Your ref: SSD-50505215

Our ref: DOC24/699892

Subject: Bullawah Wind Farm (SSD-50505215)

ATTACHMENT A – BCS Assessment Summary for Bullawah Wind Farm Environmental Impact Statement (SSD-50505215)

Projection: EPSG:7855

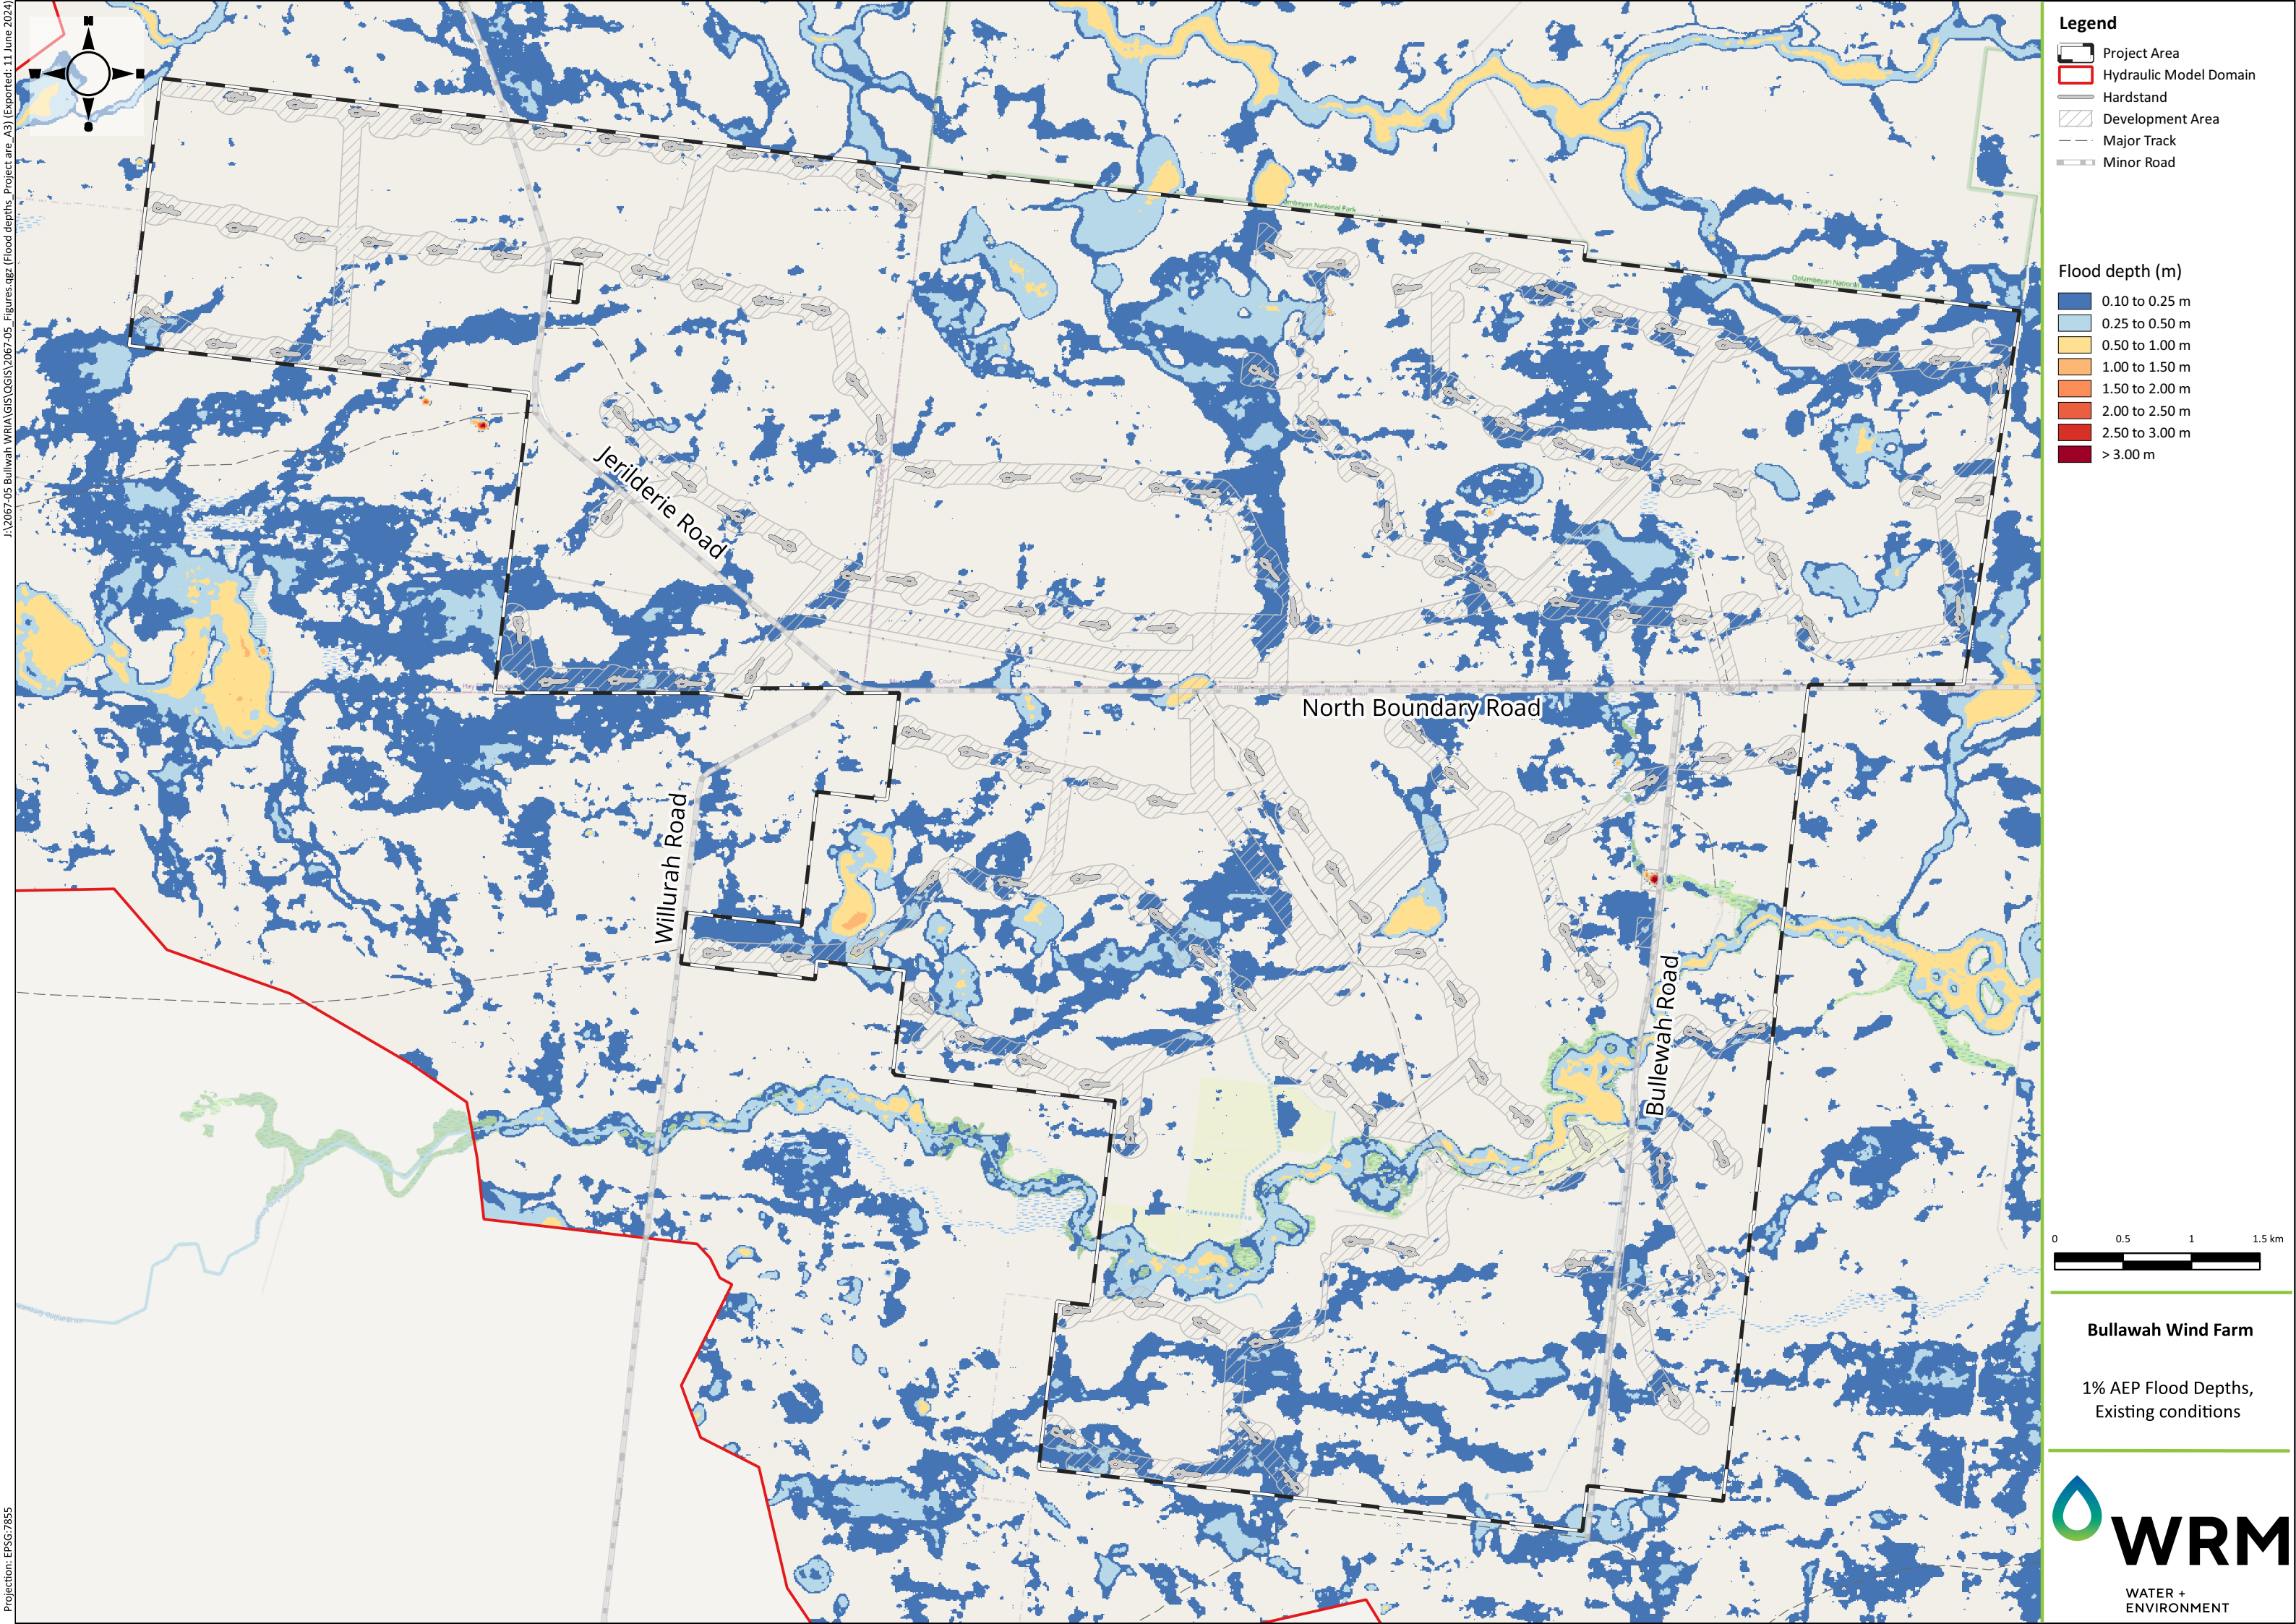
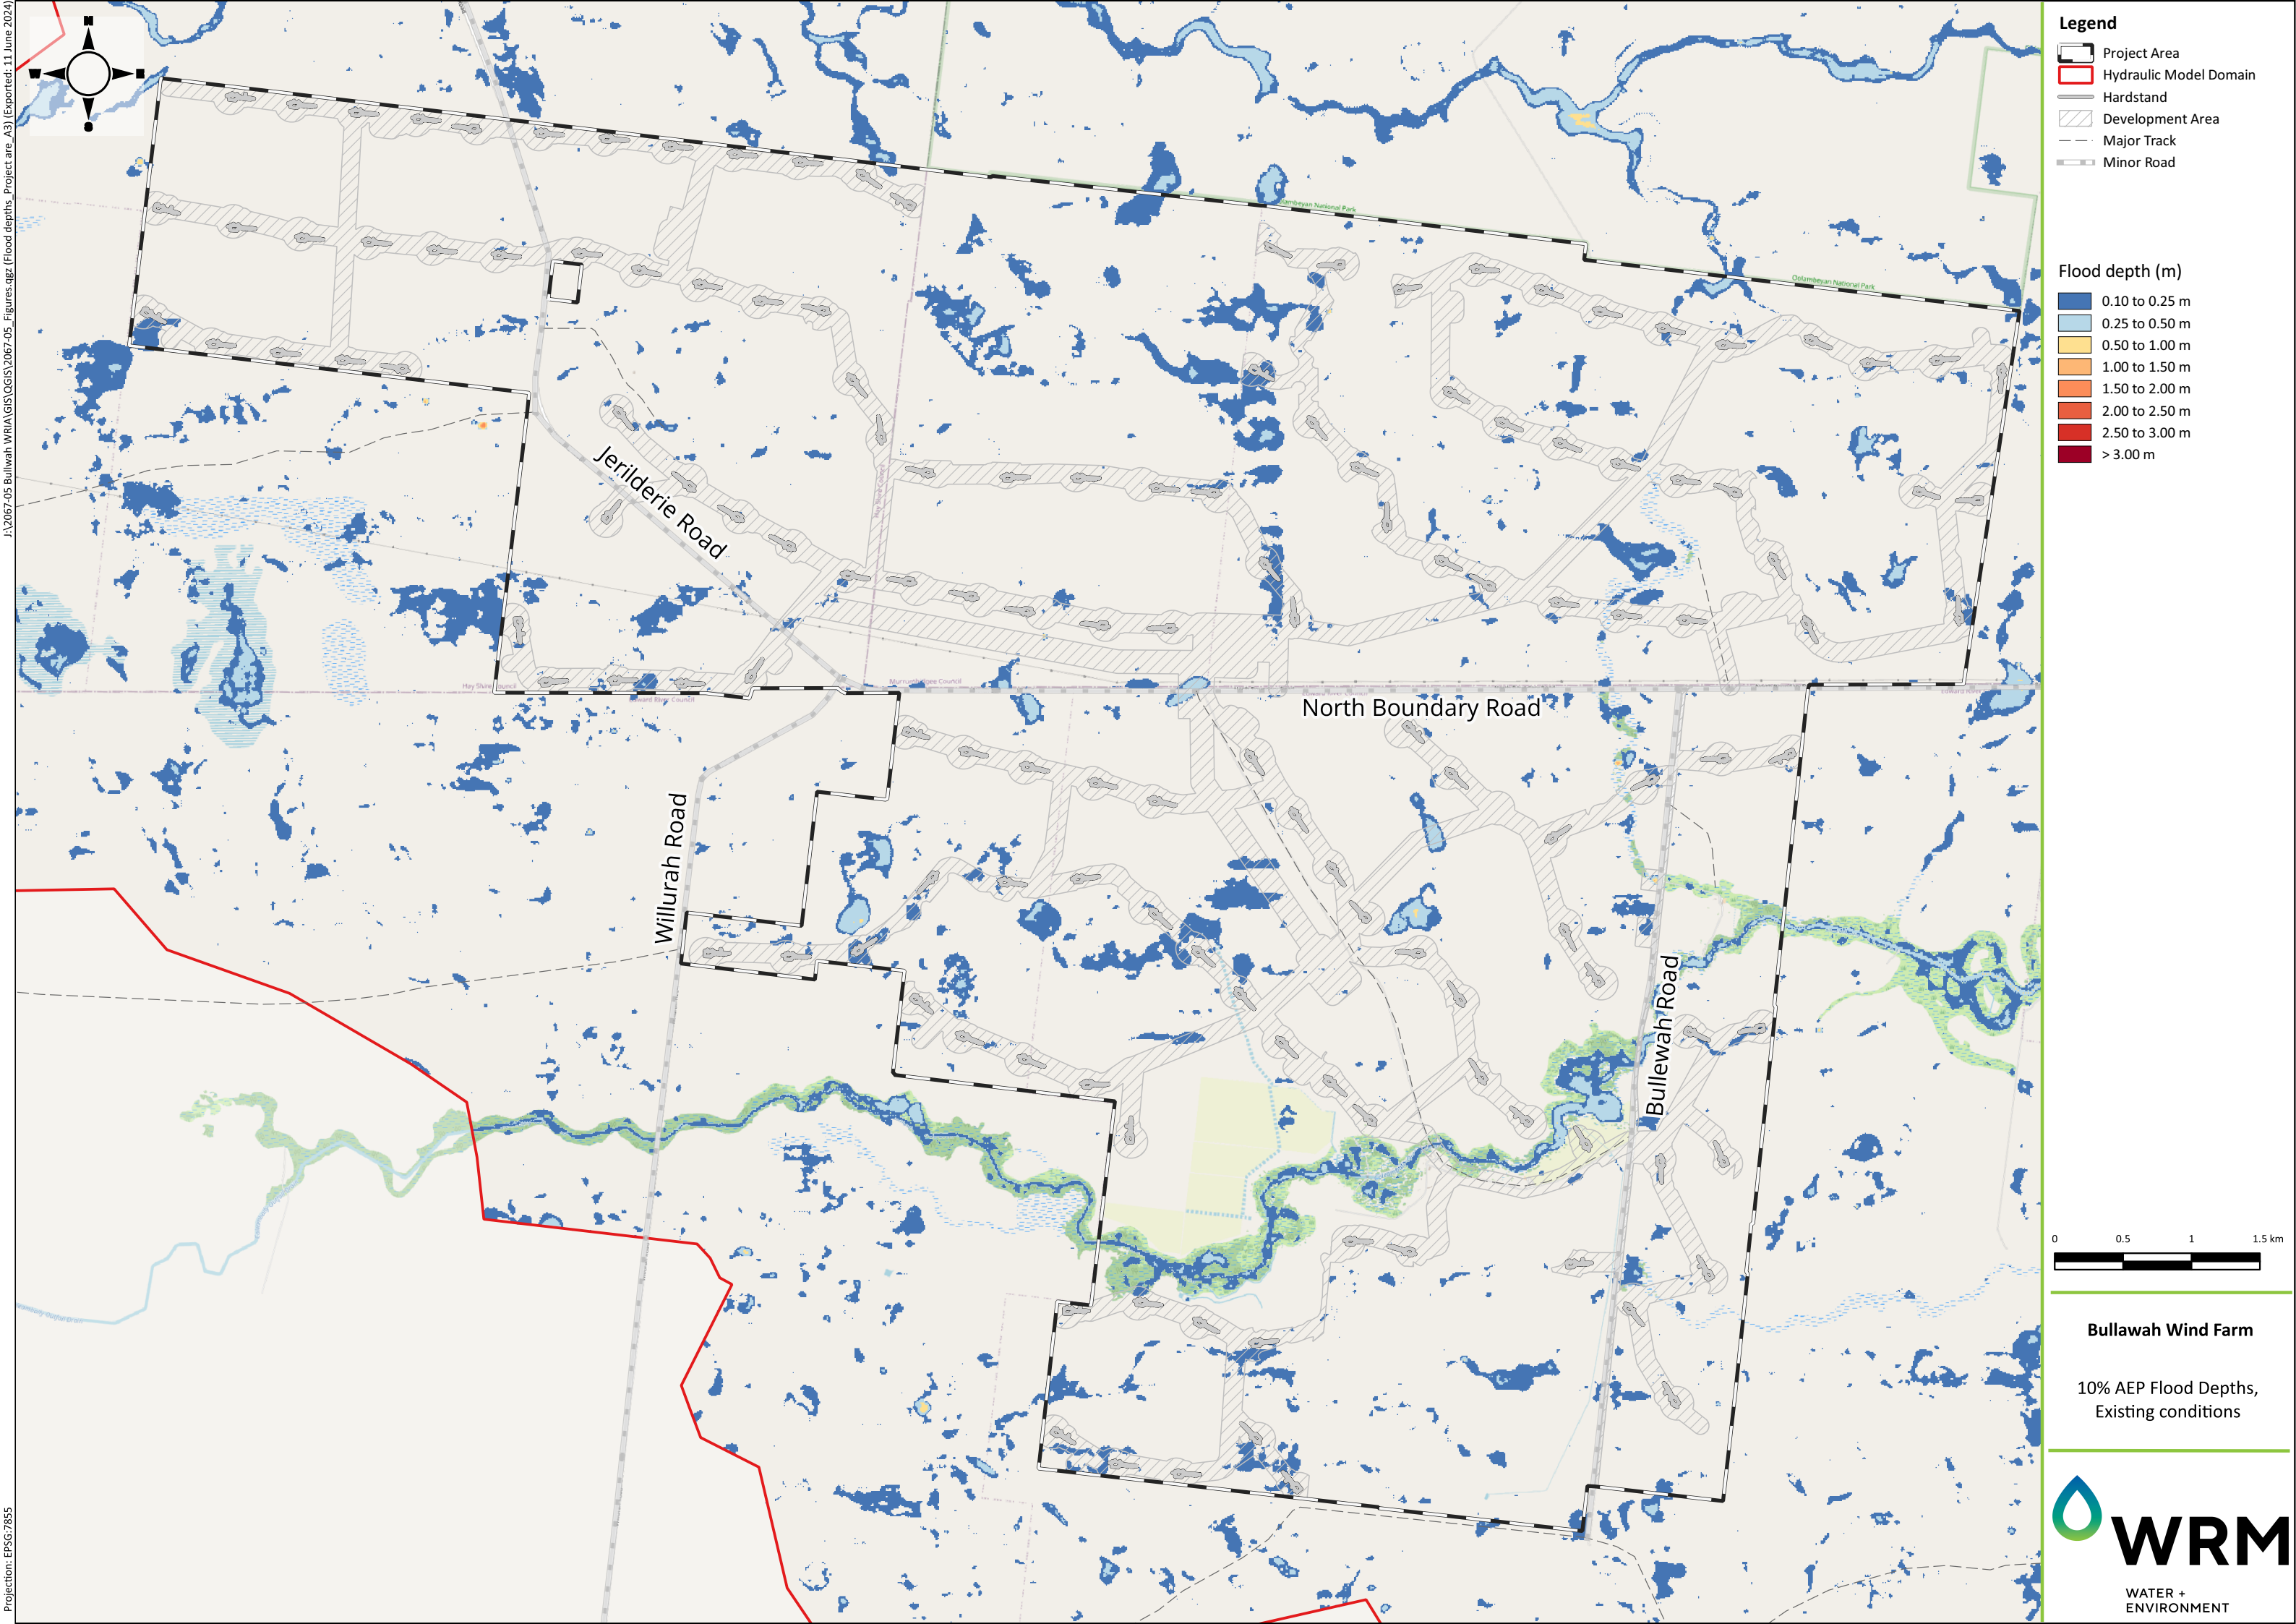
3. The flood modelling and mapping needs to include more detail of the project infrastructure to adequately inform the flood behaviour and flood risk assessment.

The Bullawah Wind Farm Project Water Resources Impact Assessment provides low-resolution mapping in its overview of the project. The mapping provides limited detail of the proposed project infrastructure, including ancillary works, in the landscape. As such, BCS is not able to determine the impact of the entire project on flood behaviour and the flood risks to the project infrastructure.

The proponent needs to complete clear and detailed mapping of sensitive and hazardous infrastructure, such as the temporary workers' accommodation, battery storage and multiple substations to allow appropriate flood risk assessment to be completed. BCS recommends that future hydraulic modelling is based on the detailed design for the project infrastructure, which will include all aspects of development, to ensure the impact of the project on flood behaviour and the flood risks to critical project infrastructure are adequately assessed.

- 3.1. Ensure future hydraulic models include the detailed design for the proposed project infrastructure to ensure the impact of the project on flood behaviour and the flood risks to critical infrastructure are adequately assessed.
